Claire Dunne, Oral Hearing Metrolink Project, 27th February 2024, The Court Dalcassian Downs Glasnevin

Drawing Title  
**Figure 14.2 Groundborne Noise from Tunnel Boring Machine Sheet 6 of 7**

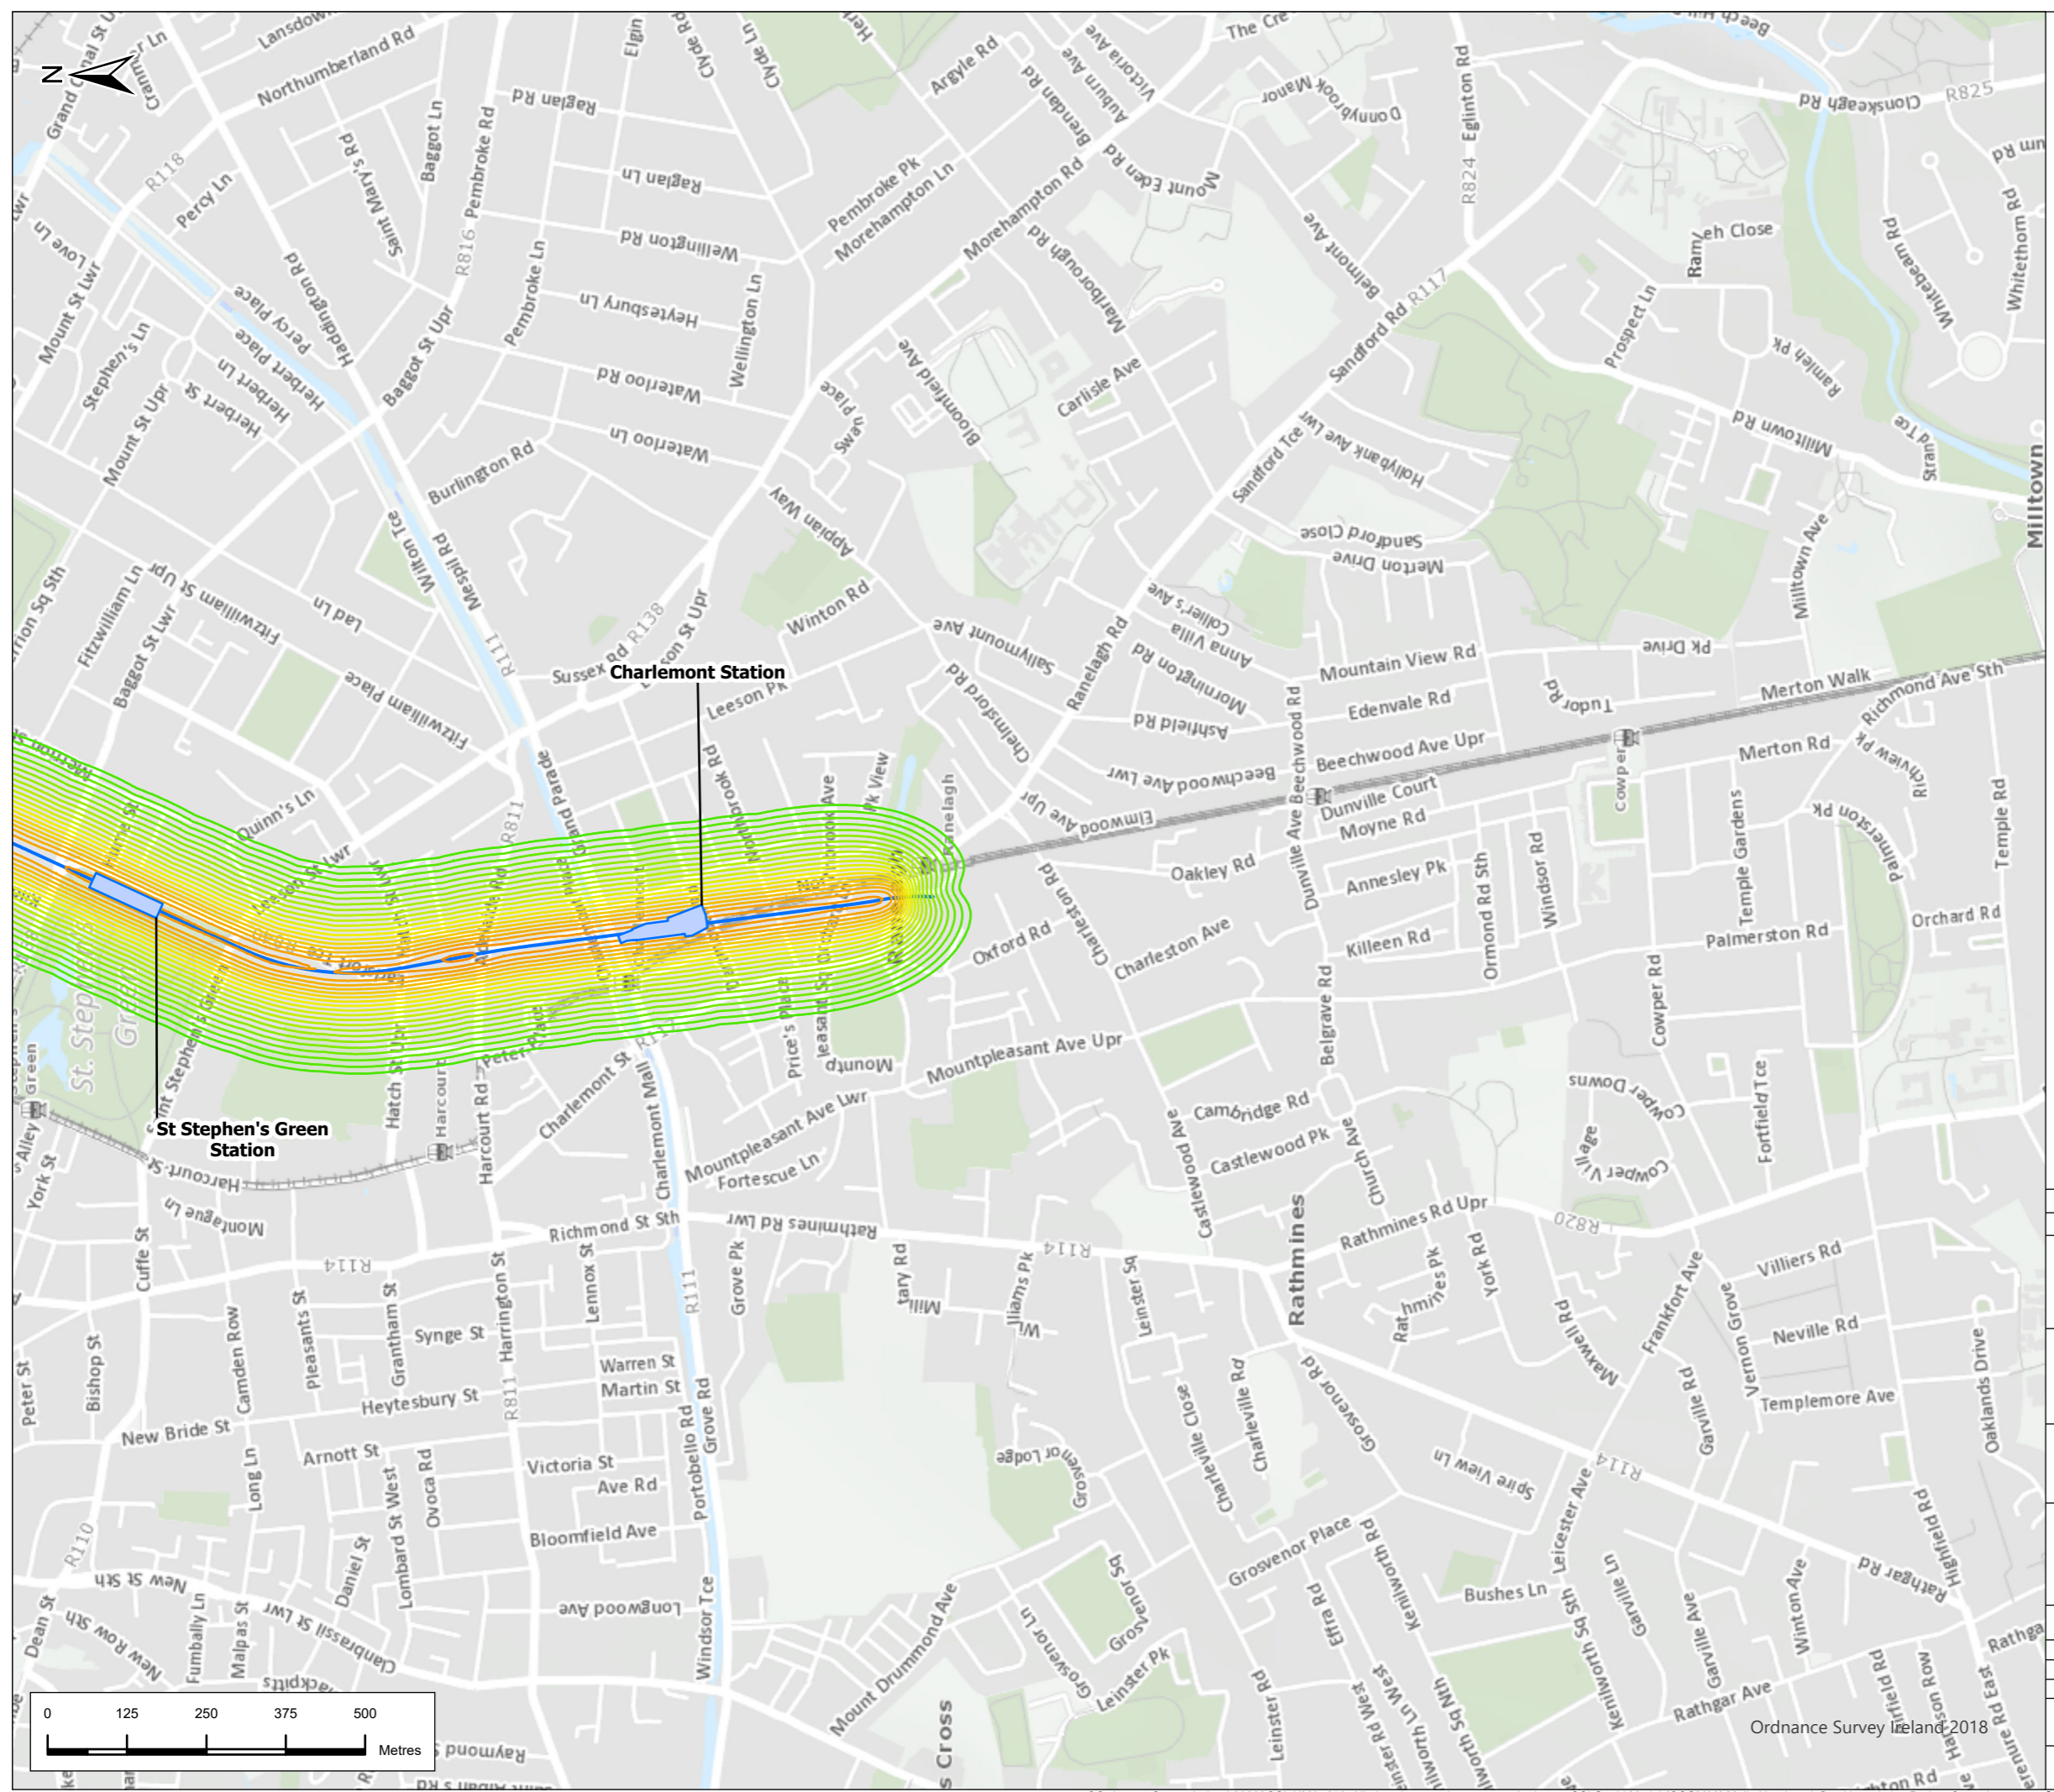
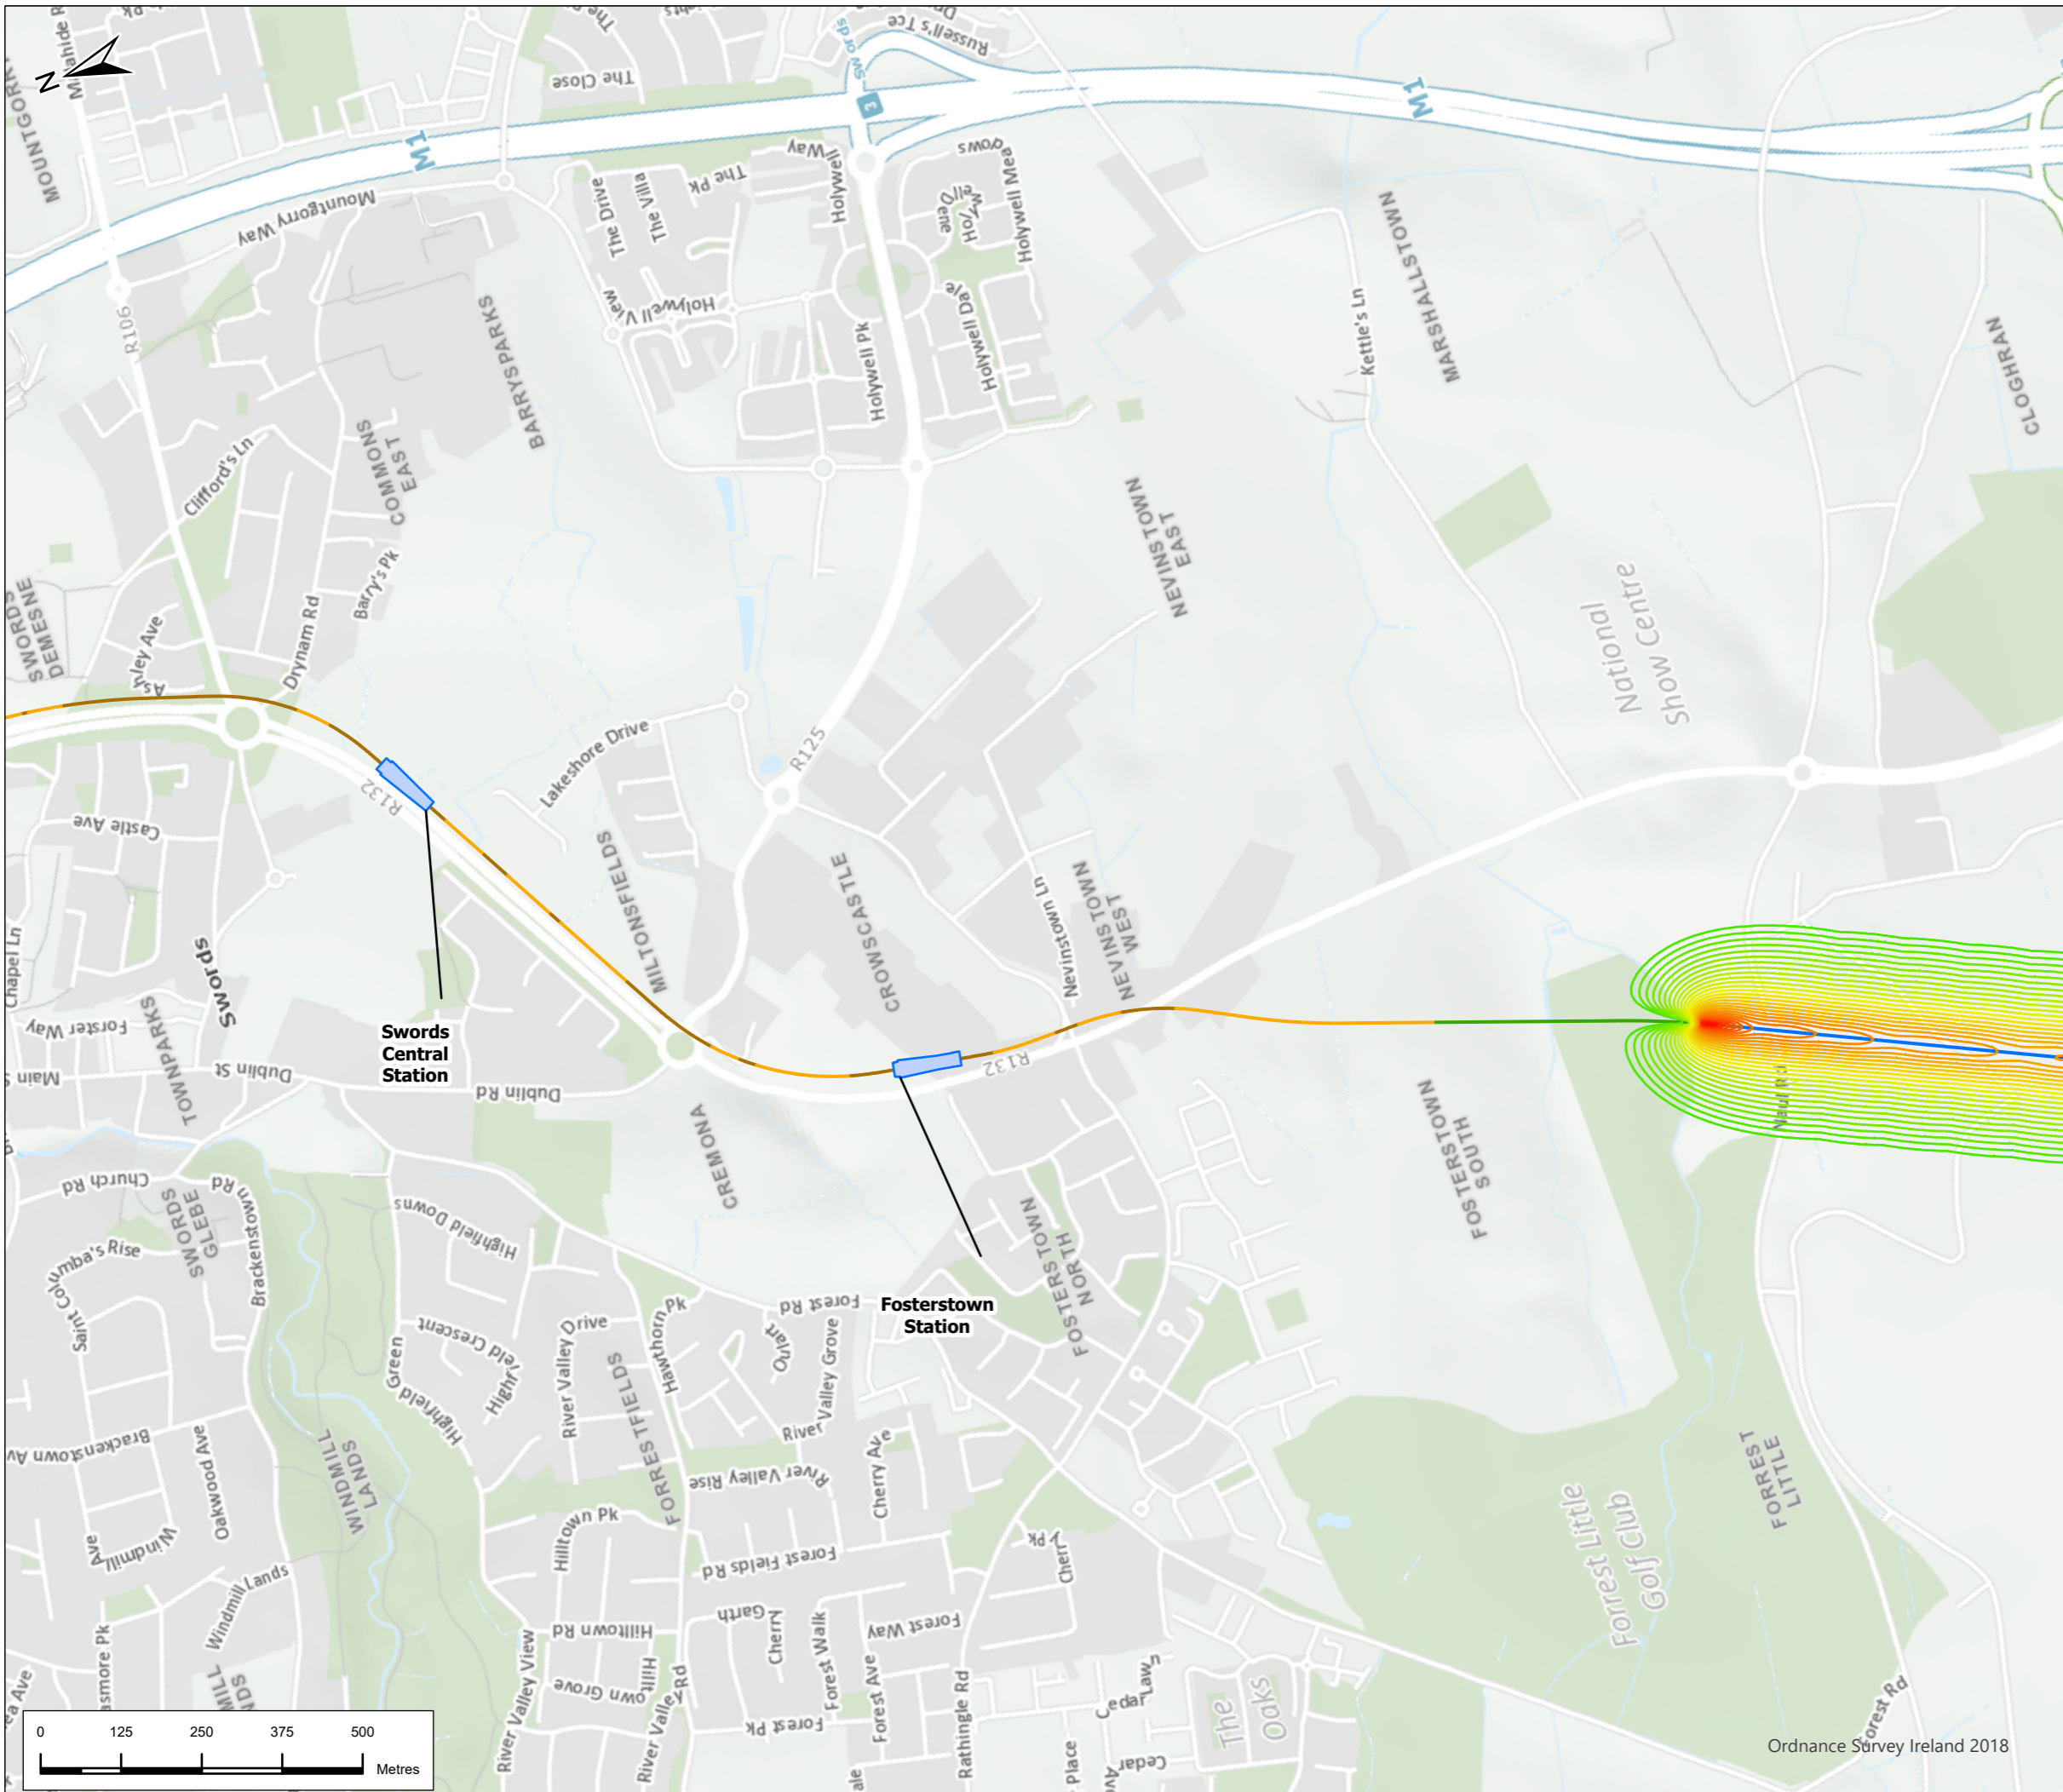
In response to my query in relation to groundborne noise and vibration you conceded that the groundborne noise while the TBM is passing below the apartment will be 49 dB, above that the threshold level of 45 dB. This will have a significant impact on the health and well-being of residents. You mentioned that TII will undertake advanced consultation and stakeholder engagement to prepare people for the passage of the TBM. What exactly does TII propose to do to minimise the impact on residents during this time? In terms of relocation how will you be able to guarantee relocation within the same area with the current rental crisis?
